CHECKLIST RESPONSES: HEADRICK RESIDENCE PHASE 2
Intake Screening - 2202-128 – Incomplete – 8822 SE 62ND ST, MERCER ISLAND

INTAKE COMMENTS PLANNING		Reviewer	Lauren Anderson	
		Email	Lauren.Anderson@mercerisland.gov	
		Status	Not Accepted – Resubmit Entire Submittal Package for Reviewer App	
Land Use actions Required				
<input type="checkbox"/>	Shoreline Permit			
<input type="checkbox"/>	Critical Area Review 1			
<input type="checkbox"/>	Critical Area Review 2			
1	<input checked="" type="checkbox"/>	Environmental Review (SEPA Checklist)		
	<input type="checkbox"/>	Accessory Dwelling Unit (ADU)		
	<input type="checkbox"/>	Lot Line Revision		
	<input type="checkbox"/>	Other		
Surveys Required Prior to Final Inspection				
	<input type="checkbox"/>	A building height survey is required prior to final inspection		
2	<input checked="" type="checkbox"/>	An impervious surface, lot coverage, and or hardscape survey is required prior to final inspection		
3	<input checked="" type="checkbox"/>	A property line/setback survey is required prior to final inspection

SECOND LEVEL
 AREA: (1,724 SF - (STAIRS) 201 SF = 1,523.00 SF

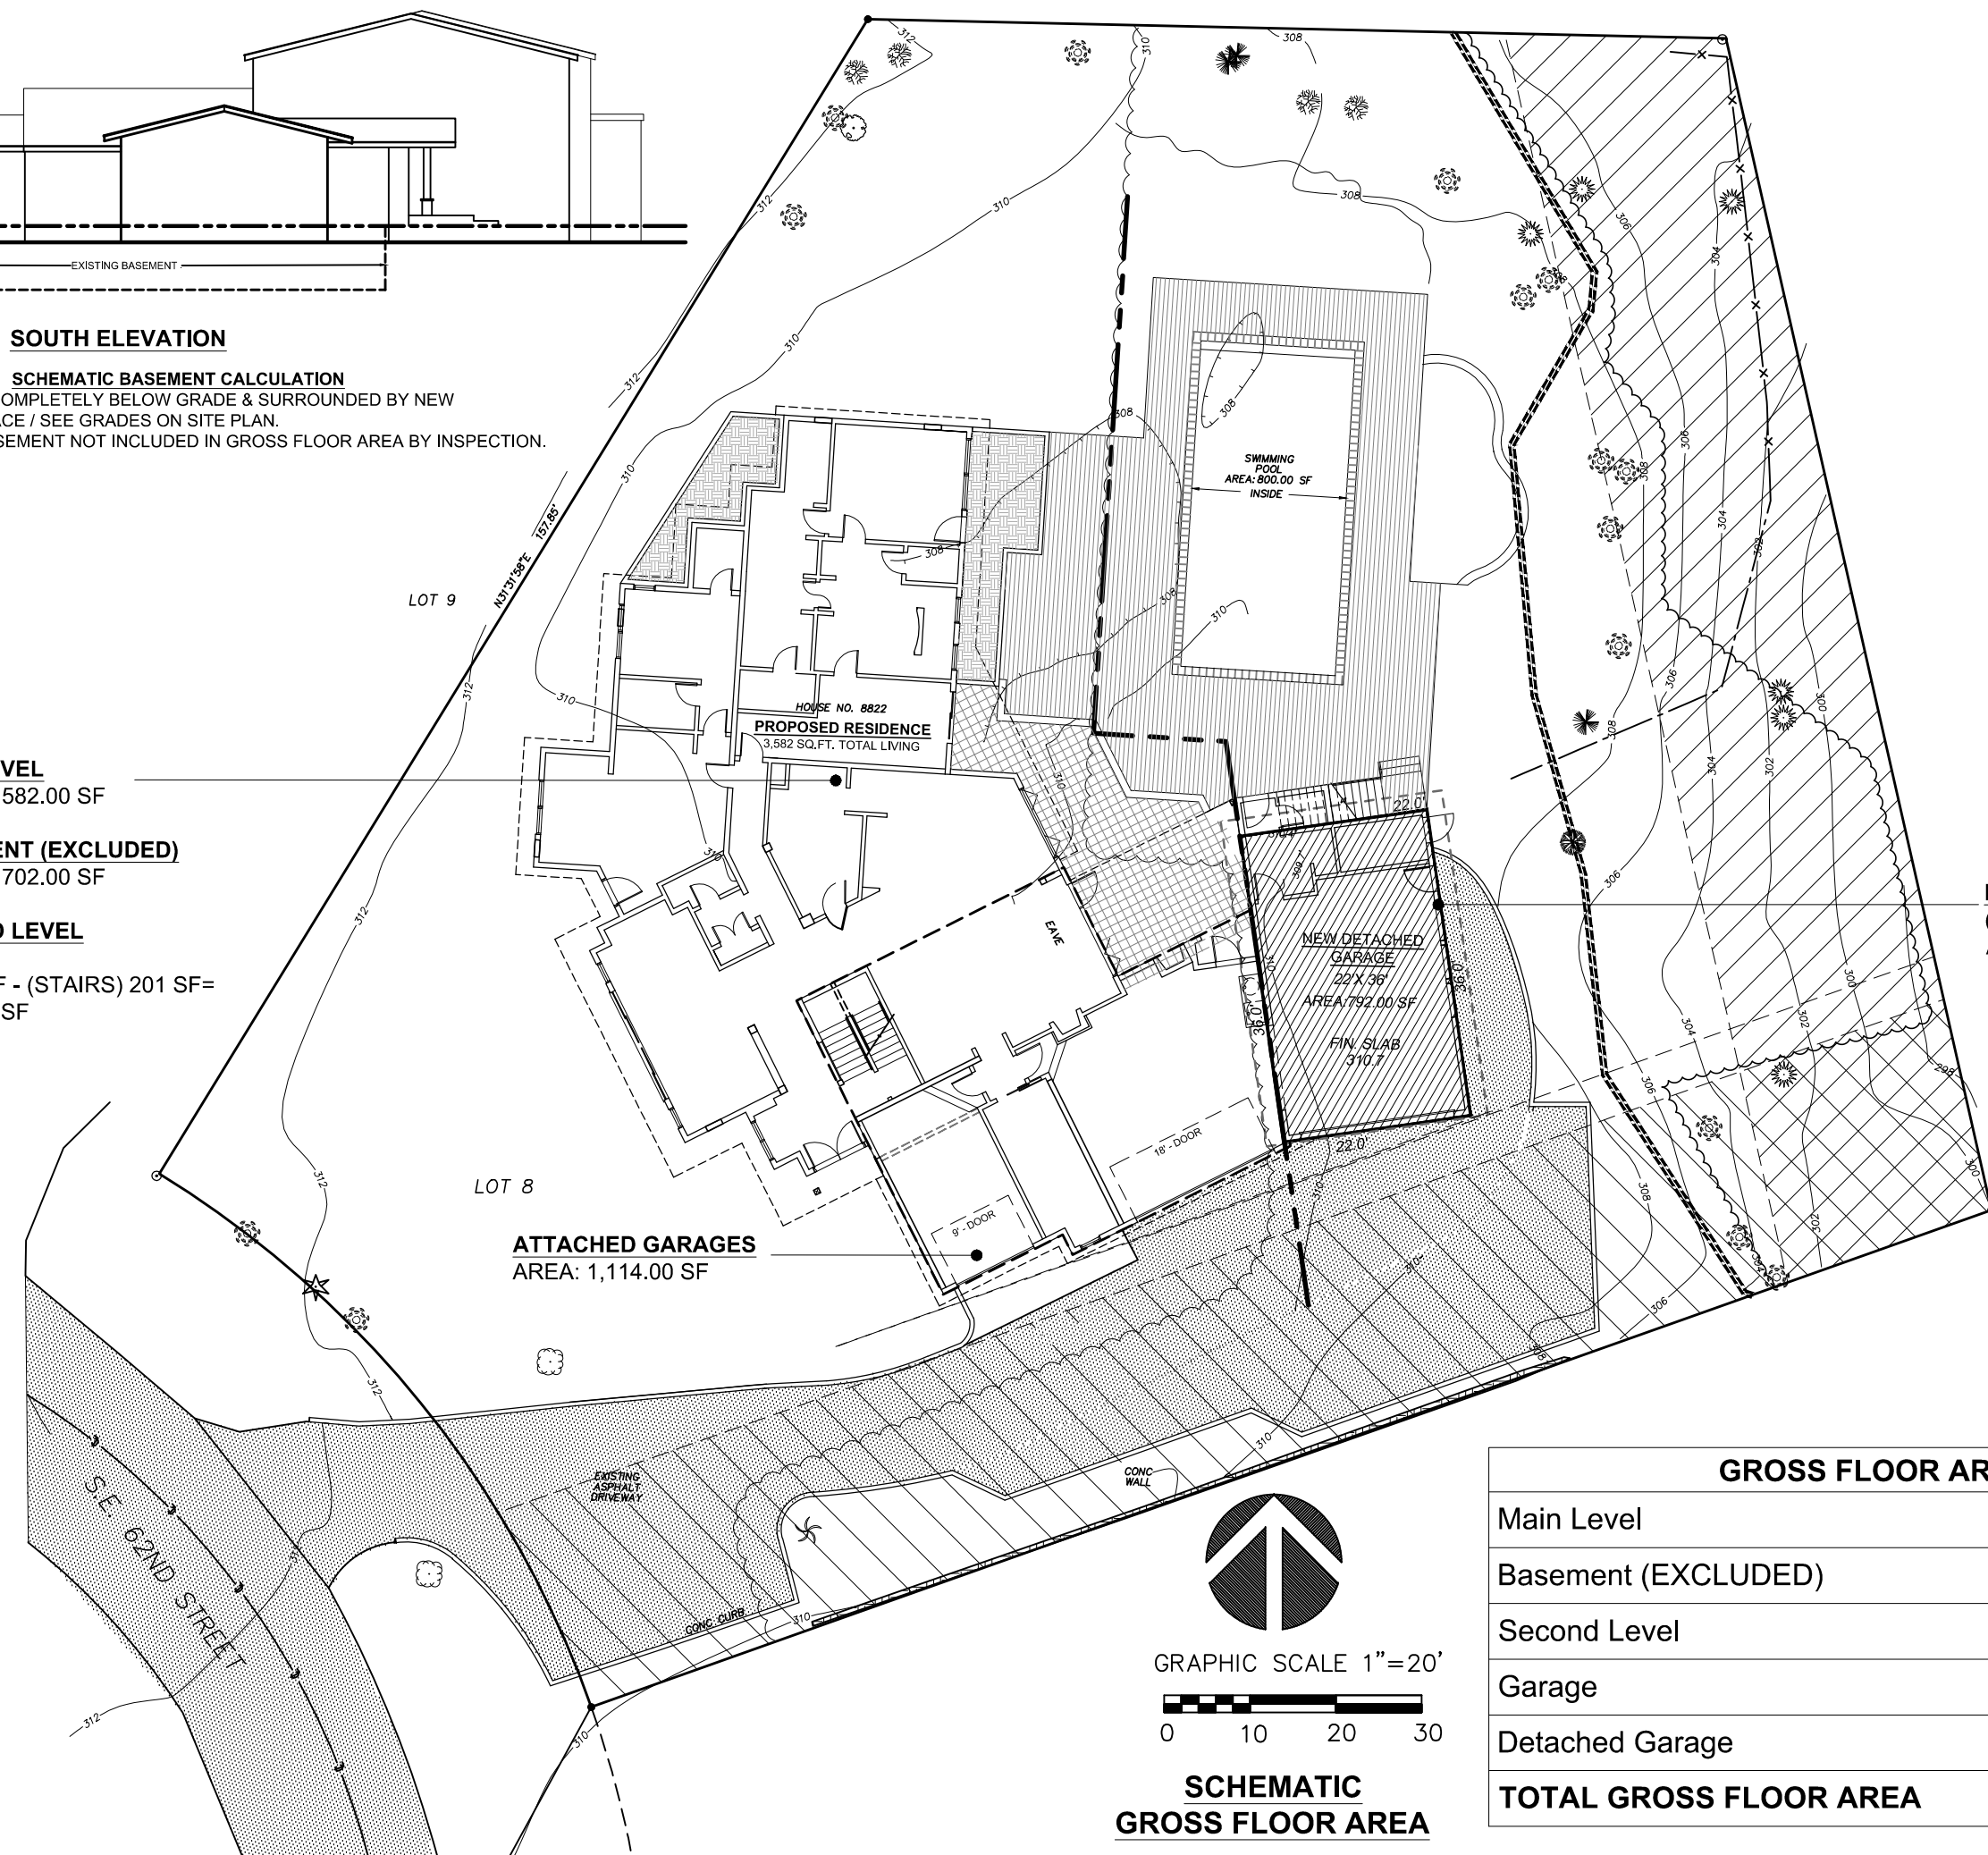
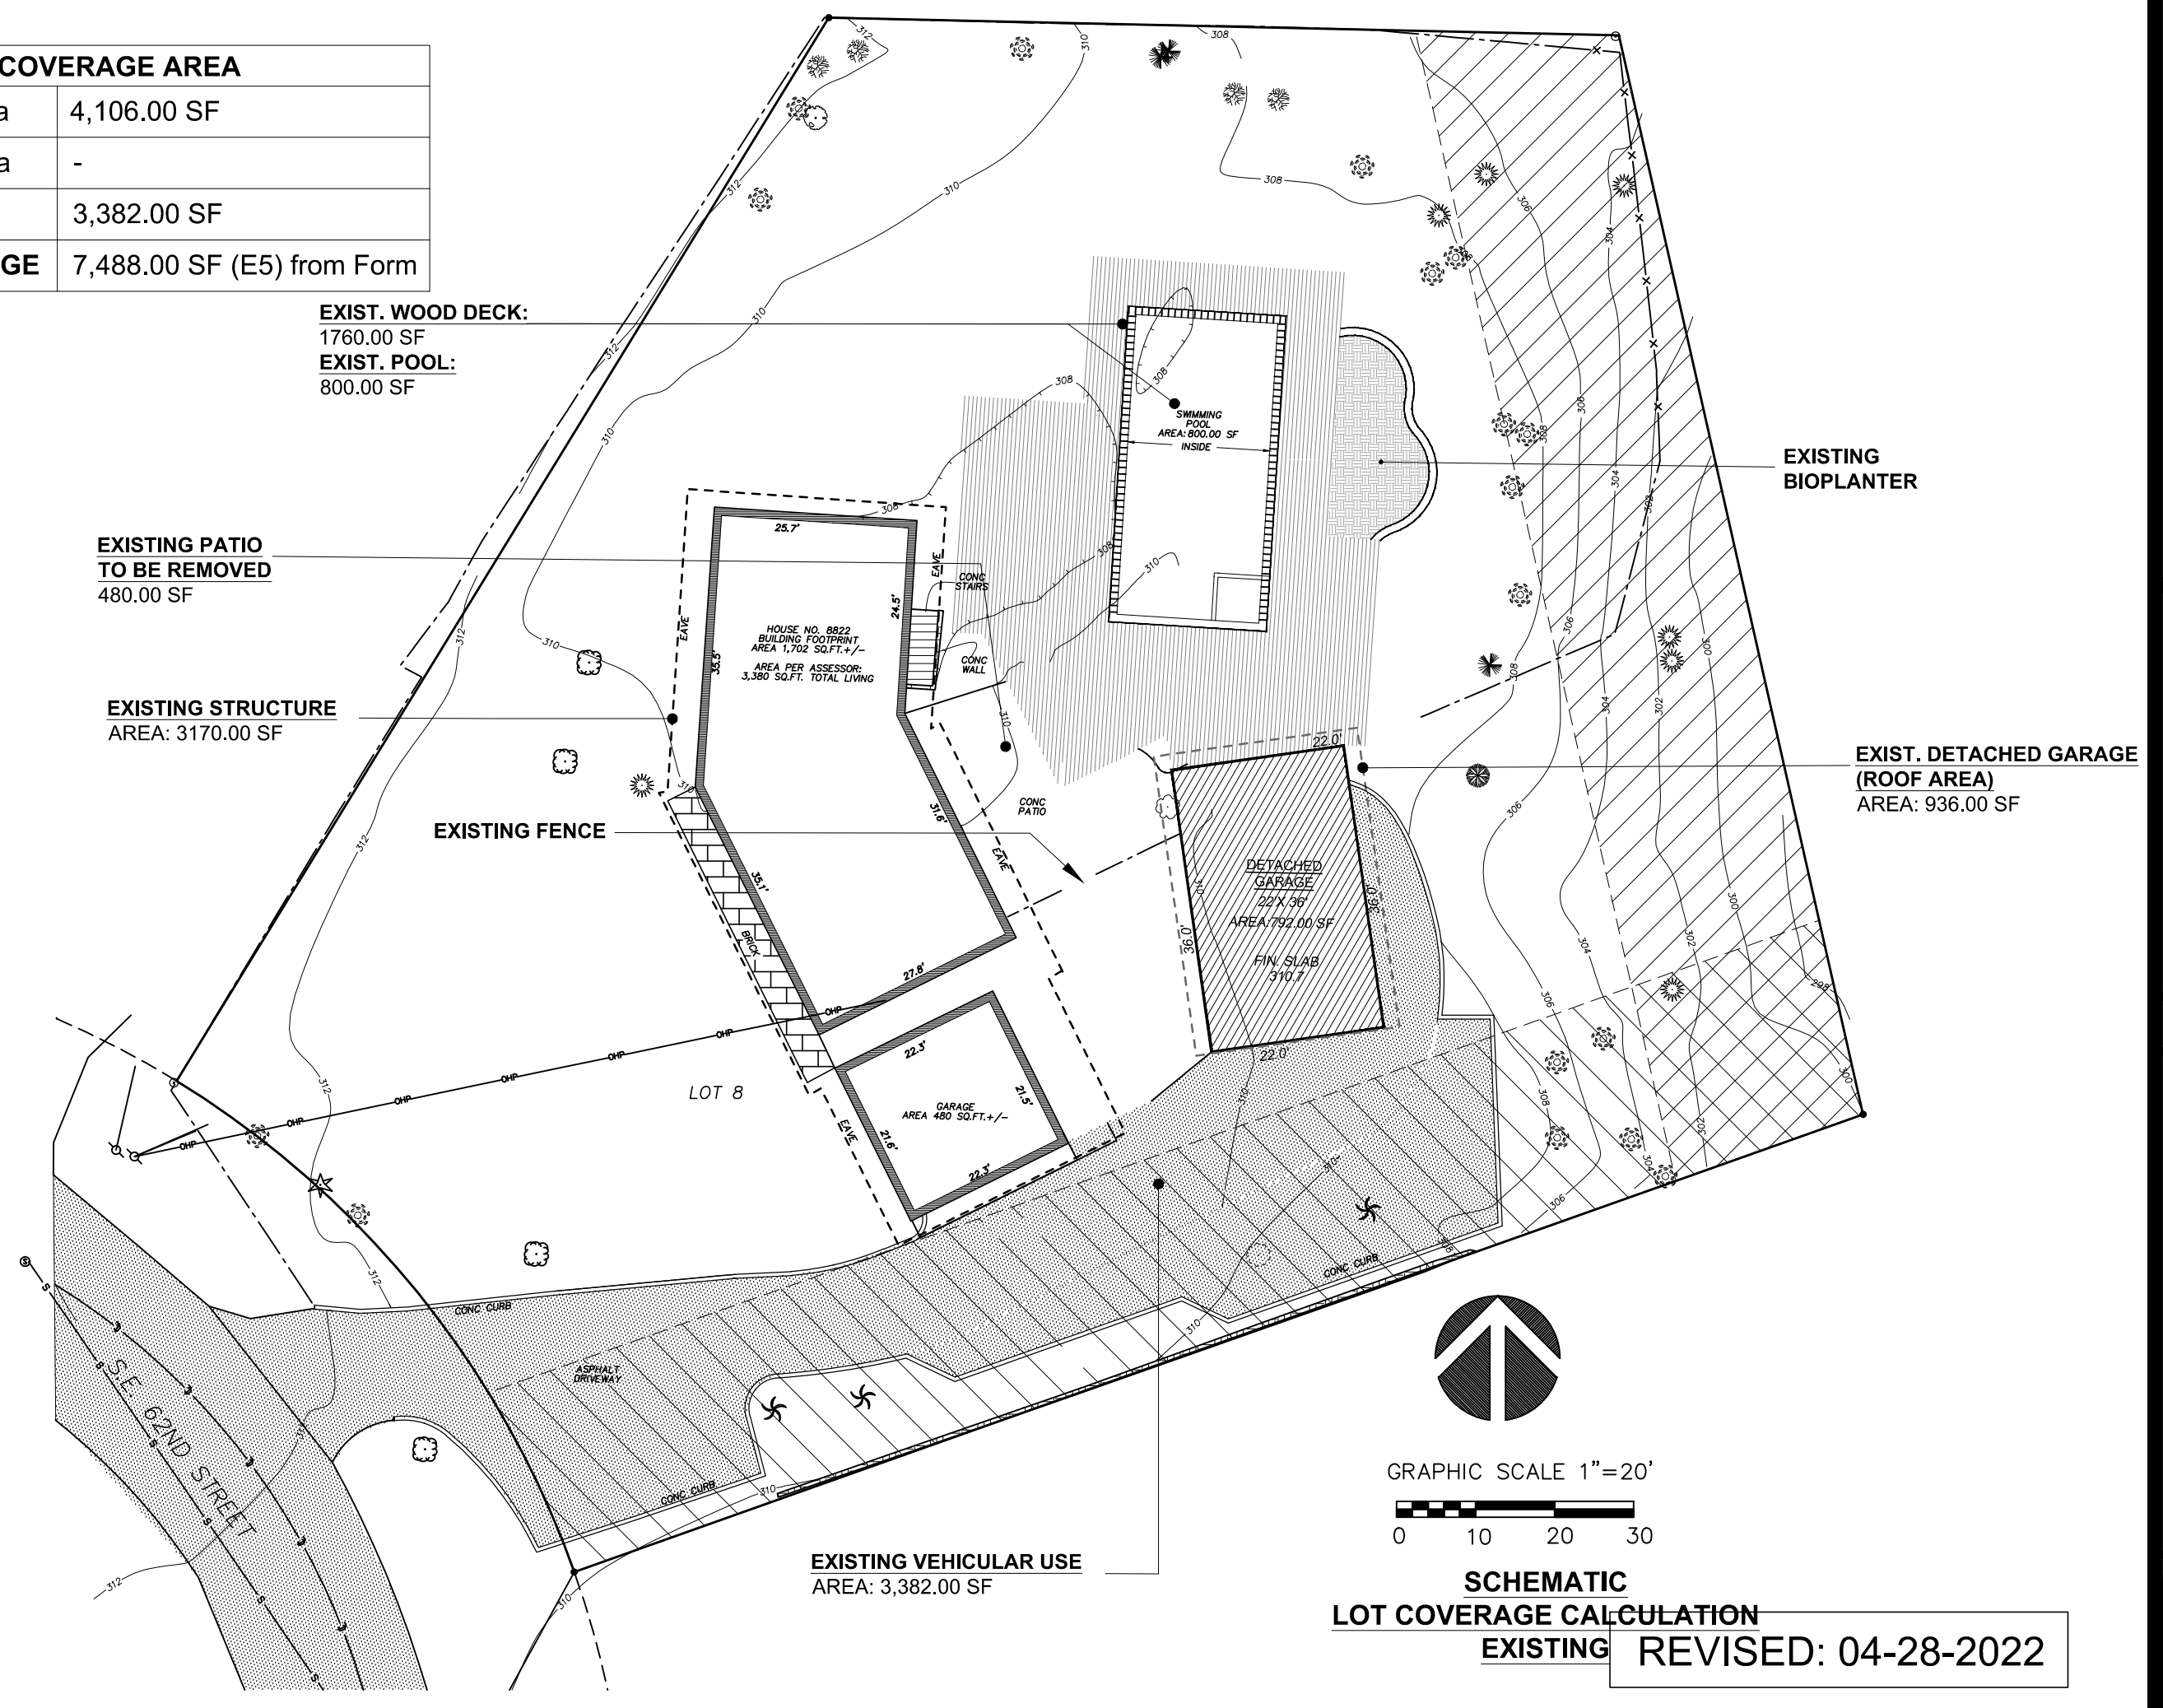
(2) A note has been added to the sheet A1 & A2.1 requiring as-built survey for impervious surface, lot coverage, and or hardscape area prior to final inspection

(3) A note has been added to the sheet A1 & A2.1 requiring as-built survey for property line/setback survey prior to final inspection.

(4) A site plan has been added showing dimensioned foundation & location, setbacks, and property lines. See sheet A2.1

(11) Indicate utility easements. Shown on site plan A2. Text of easements on sheet A2.1

18 Plan set: Label the 25' storm easement and the note recording number (198809140722). Label the sewer & storm easement and note the recording number (198202230542).

(18) Storm drainage easement and storm maintenance easement shown on site plan A2. Easement documents shown on sheet A2.1.
